30 January 2019

File No: R/2018/14/A
Our Ref: 2019/033705

**Waterloo Metro Quarter Precinct Over Station Development – Concept State
Significant Development Application – SSD 9393**

Figure 16 – Proposed building configuration and separation

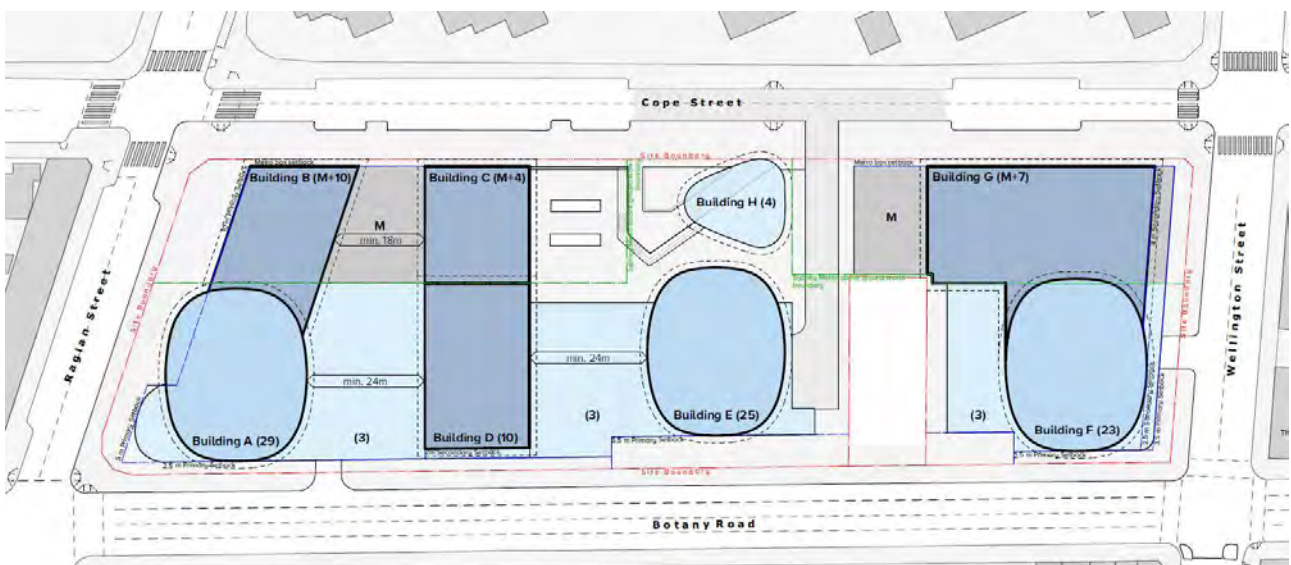
The proposed intrusions into the minimum separation zones are not supported on the basis of residential amenity. The building envelopes are to be modified to ensure that balconies do not encroach into the minimum 24m separation distance (includes the balcony depth) for building heights over 25m, in accordance with objectives of the Apartment Design Guide.

Fig. 10.2.3.1 Solar Access to adjacent context

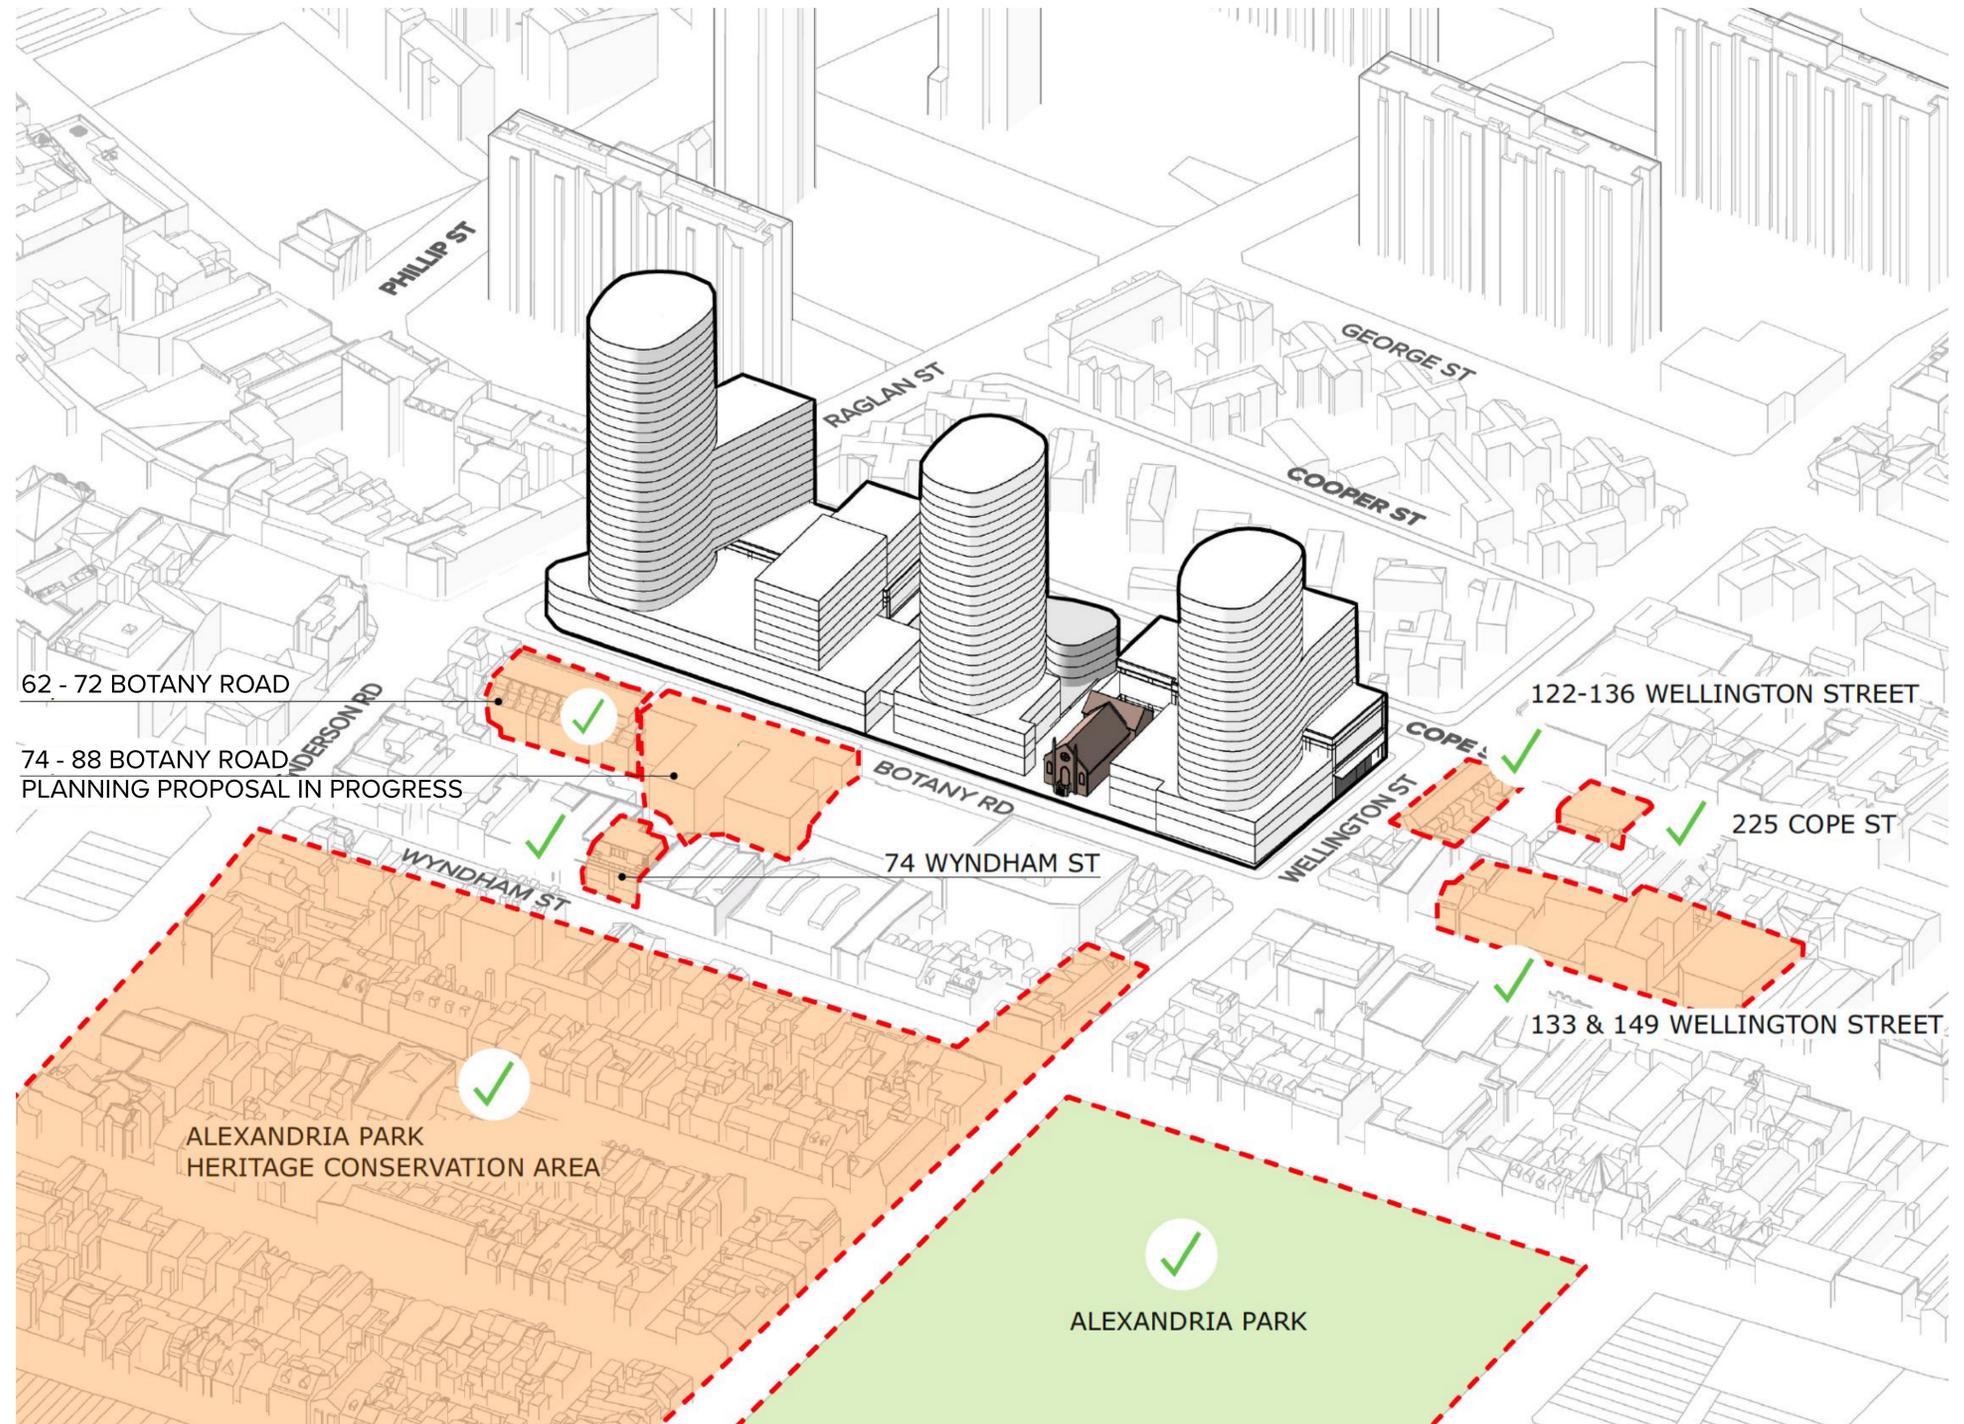
The proposed tower development overshadows portions of the north eastern corner of the park at 9am at mid-winter. While not a numeric non-compliance with the existing site controls, any overshadowing to Alexandria Park is unacceptable to the City for the following reasons:

10.2.4 PEDESTRIAN ENVIRONMENT

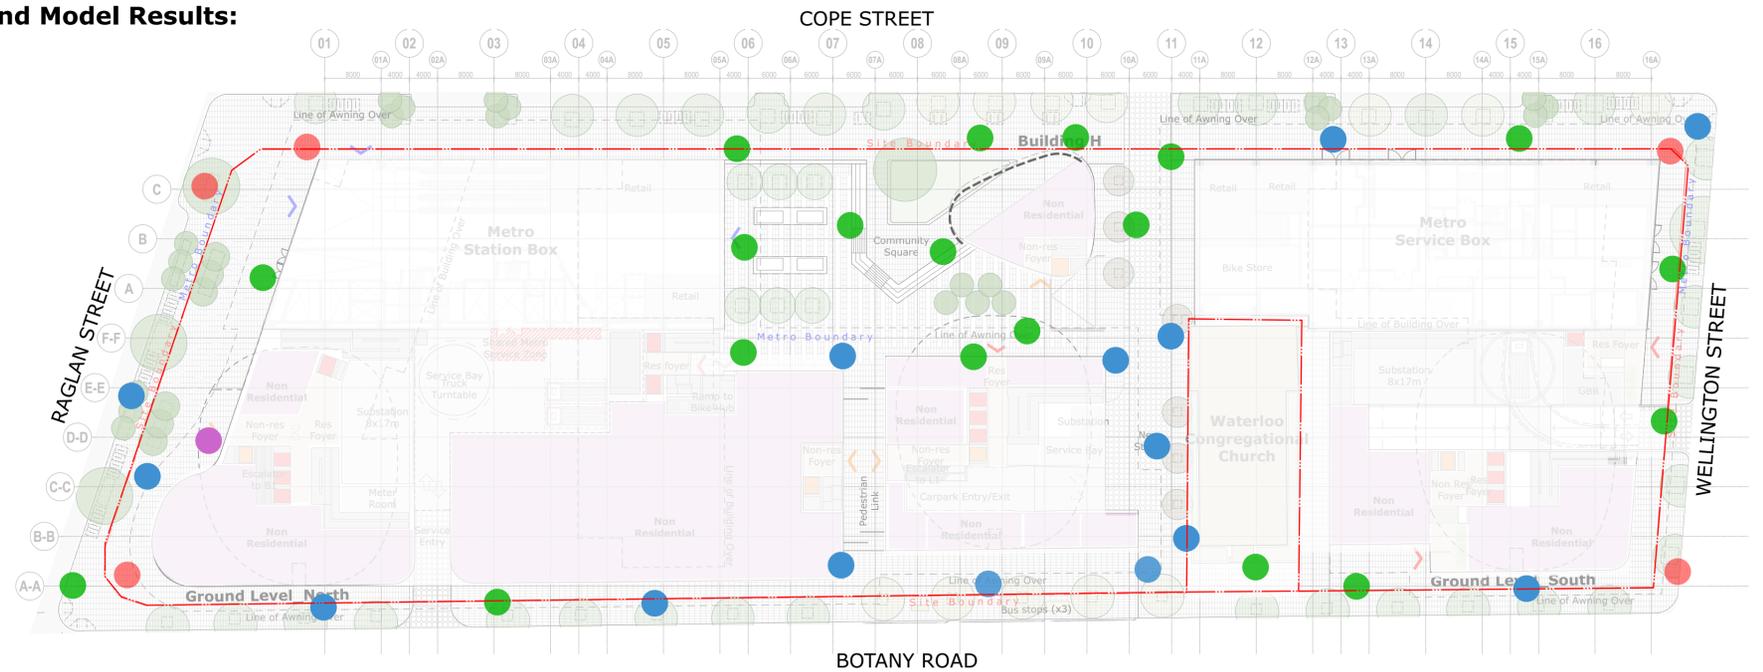
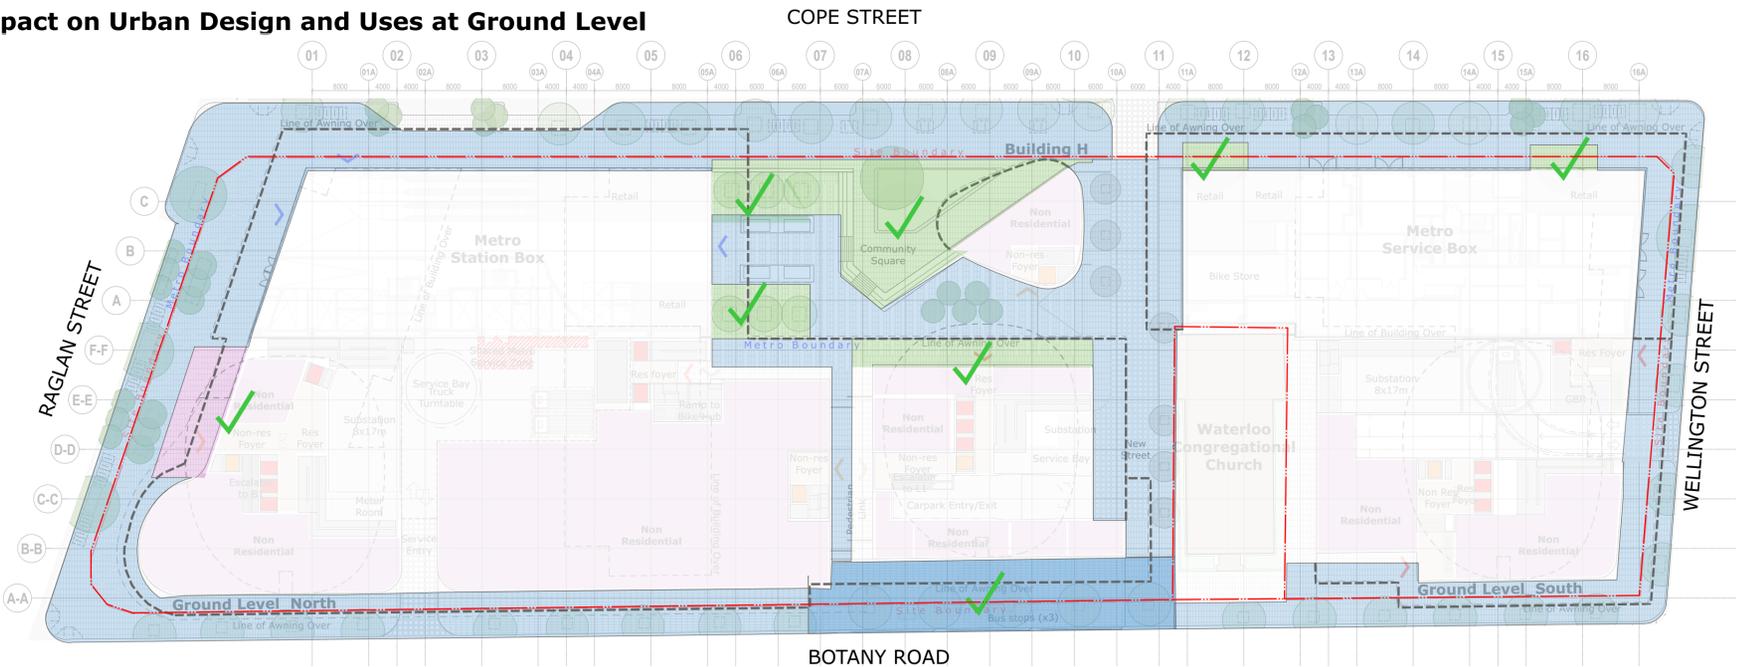
The Wind Report identifies a through-site link located between the church and the central podium as being prone to adverse wind conditions due to down washing off the central tall building (Building E) onto the link. Direct westerly and north-easterly winds funnel through the through-site link worsening conditions. The report recommends use of an impermeable awning over these areas to assist the downwash wind. This structure will have the effect of deflecting wind from the generous public pedestrian link that has been specifically designed to physically separate the heritage item from the podium and tower to the north and provide an appropriate setting/curtilage to the church.

As the Waterloo Congregational Church is a significant, pre-existing site constraint, the design of the new podium and towers must be amended to ensure that the setting of this heritage item is optimised and its fabric conserved. An impermeable wind deflection structure adjacent to the church is not acceptable. The configuration of podium and tower adjacent to the pedestrian link north of the church needs to be amended in order to reduce any wind downwash/impacts to an acceptable level of pedestrian comfort without the need for an impermeable awning or other intrusive structures. These design changes may need to deal with a number of variables including tower set-backs, tower shape, façade modulation of the tower and podium, etc.
